CITY OF PORTLAND BUILDING PERMIT

Located At 11 DEERING ST

Job ID: 2012-04-3696-ALTR

has permission to Rebuild Existing Porch (Two Family Residence).

A-5
 Section Detail Thru Porch
 3/4" = 1'

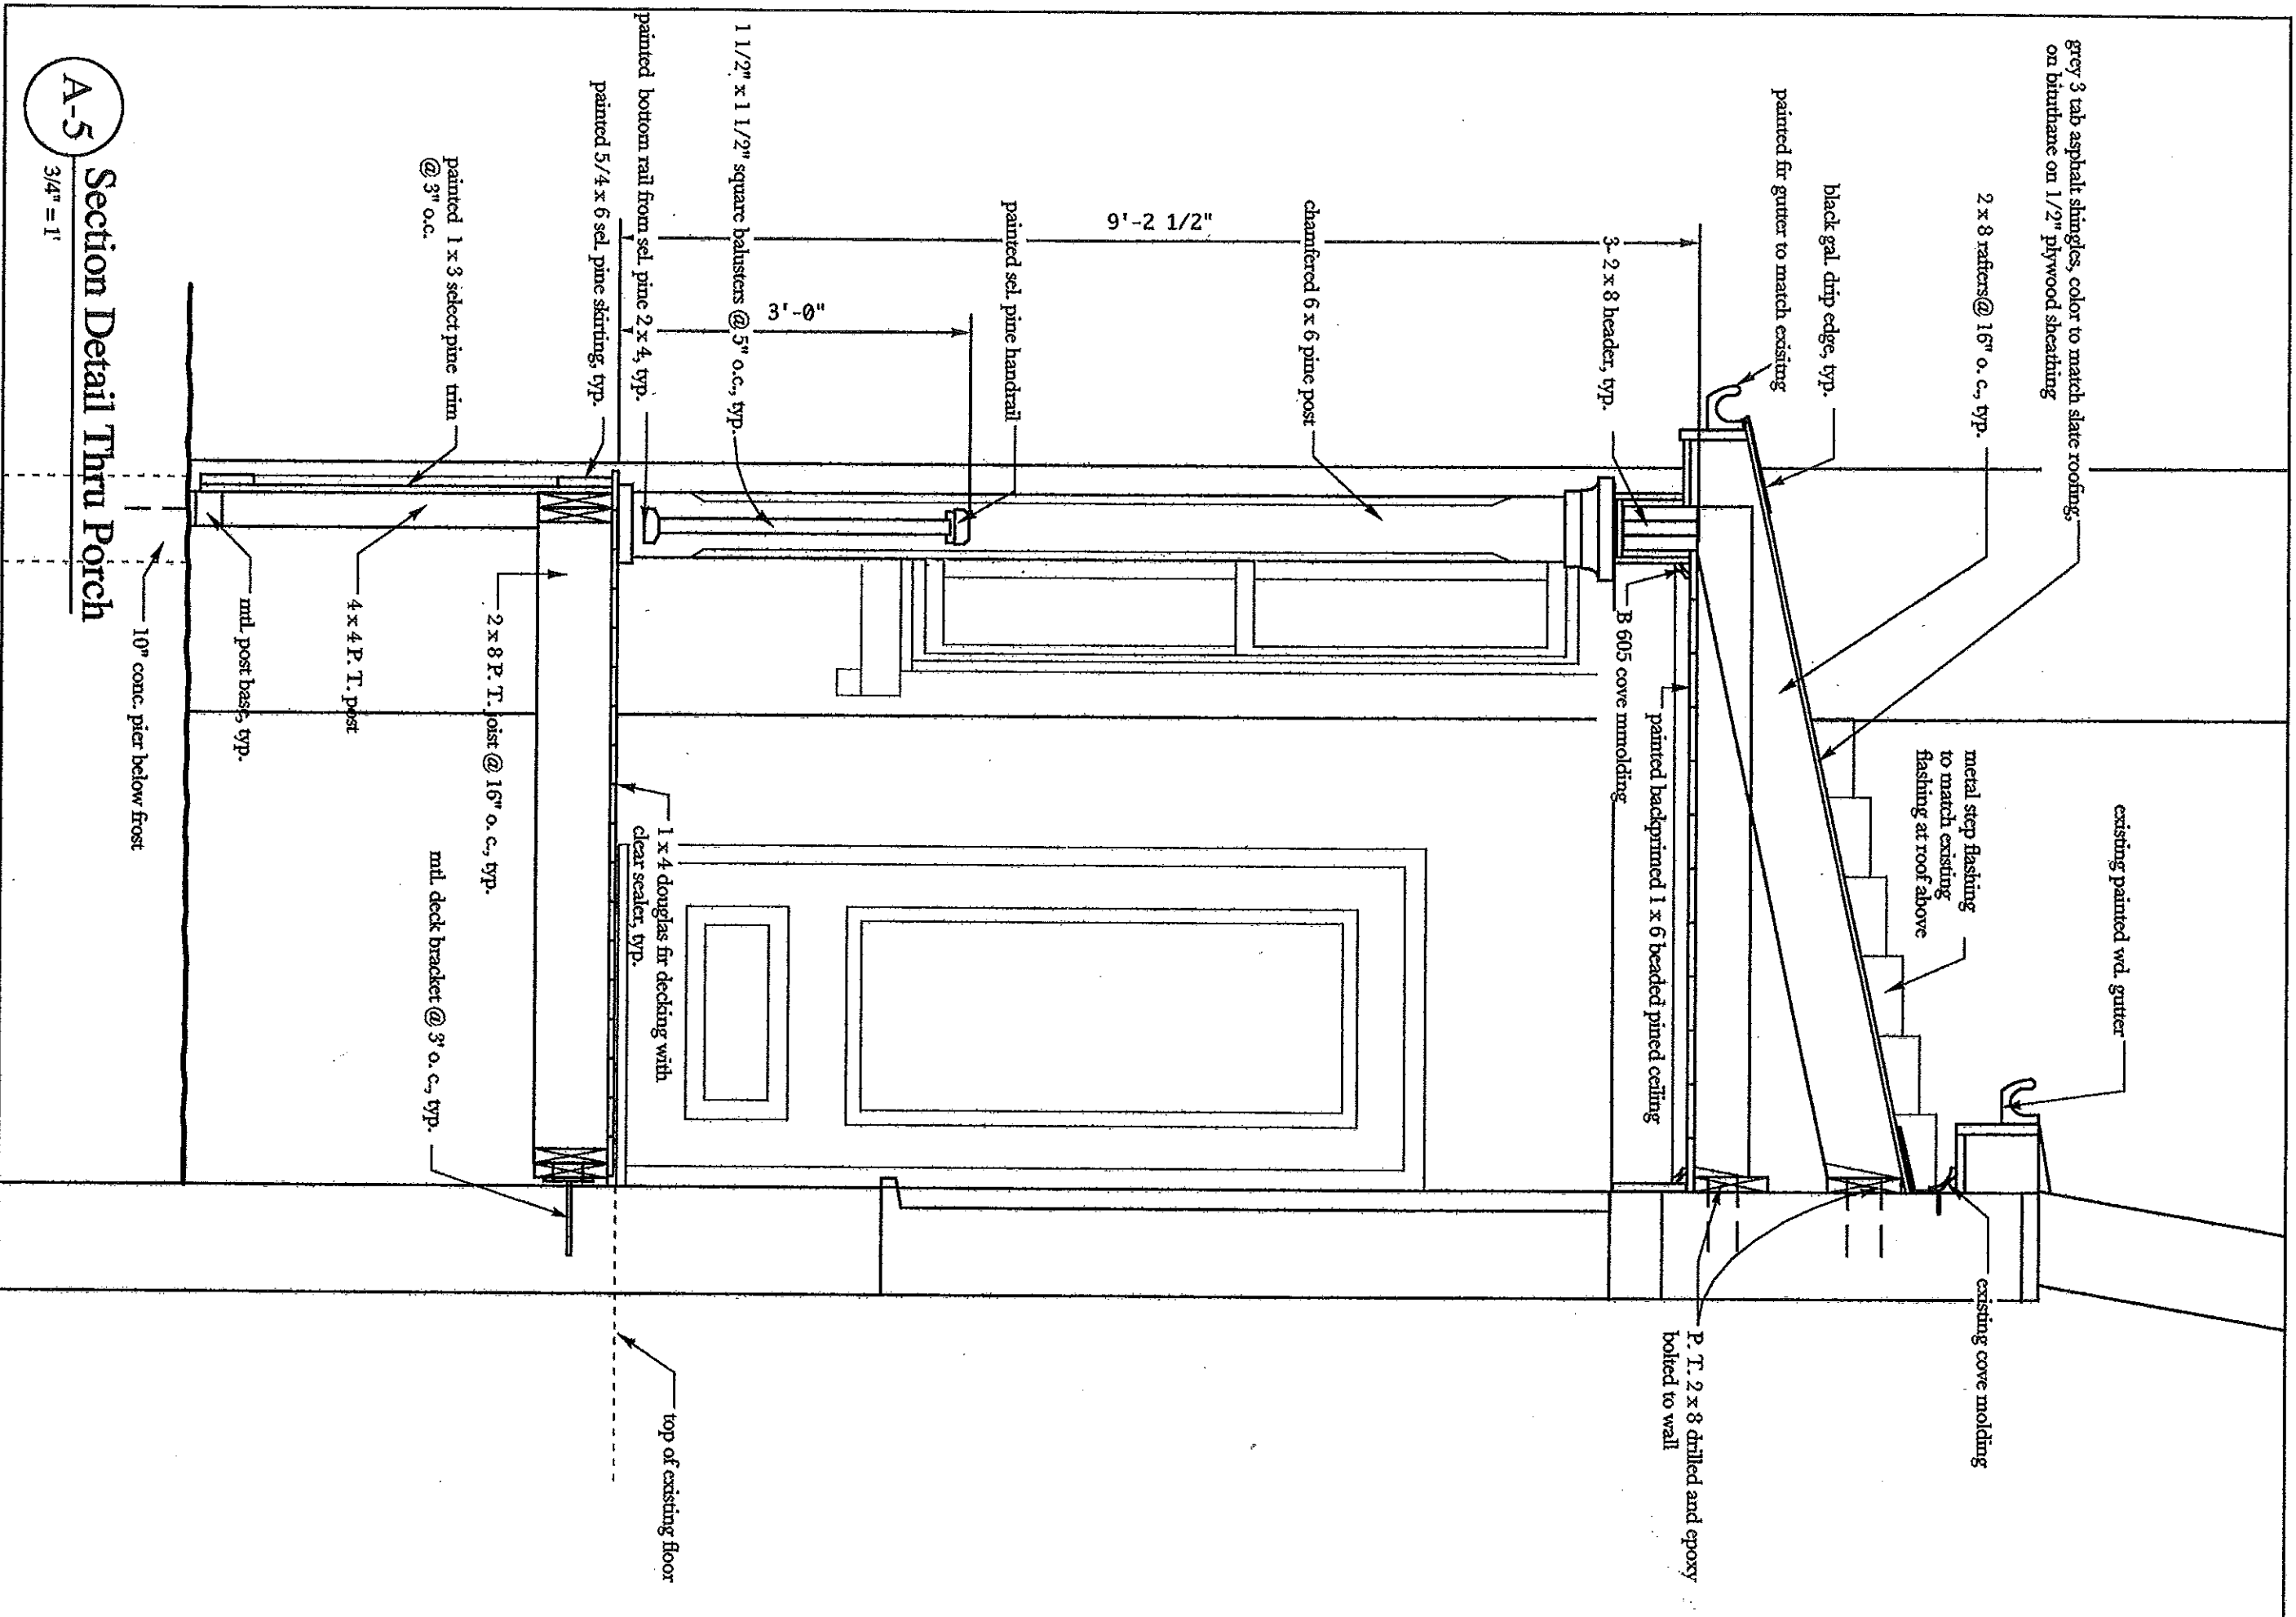
1. Any exterior lighting, with the exception of recessed lighting, to be reviewed and approved by HP staff.
2. Cove molding to be applied to exterior face of porch fascia, consistent with treatment on original ell's fascia.
3. If walkway is replaced as part of this project, HP staff must review and approval material selection.

1. Separate permits are required for any electrical: plumbing, sprinkler, fire alarm, HVAC systems, commercial hood exhaust systems and fuel tanks. Separate plans may need to be submitted for approval as a part of this process.
2. Frost protection must be installed per the enclosed detail as discussed w/owner/contractor (at least 4' from grade).
3. A graspable handrail (34-38 inches in height) shall be provided on at least one side of each continuous run of treads or flight with four or more risers. Fall protection (36 inches) from exterior decks may be required if floor joist are at or above thirty (30) inches from grade.
4. R312.3 Opening limitations. Required guards shall not have openings from the walking surface to the required guard height which allow passage of a sphere 4 inches in diameter.

7. Section R317 Protection of Wood and Wood Based Products against decay. All wood framing members that rest on concrete or masonry exterior foundation walls and are less than 8 inches from the exposed ground.

8. R502.6 Bearing. The ends of each joist, beam or girder shall have not less than 1.5 inches of bearing on wood or metal and not less than 3 inches on masonry or concrete except where supported on a 1-inch-by-4-inch ribbon strip and nailed to the adjacent stud or by the use of approved joist hangers.

9. Note: Max span for the (3) 2 X 8 inch beams will be 7 foot 5 inches between each post (or verify with the project Architect). The means of egress shall not be effected during construction.
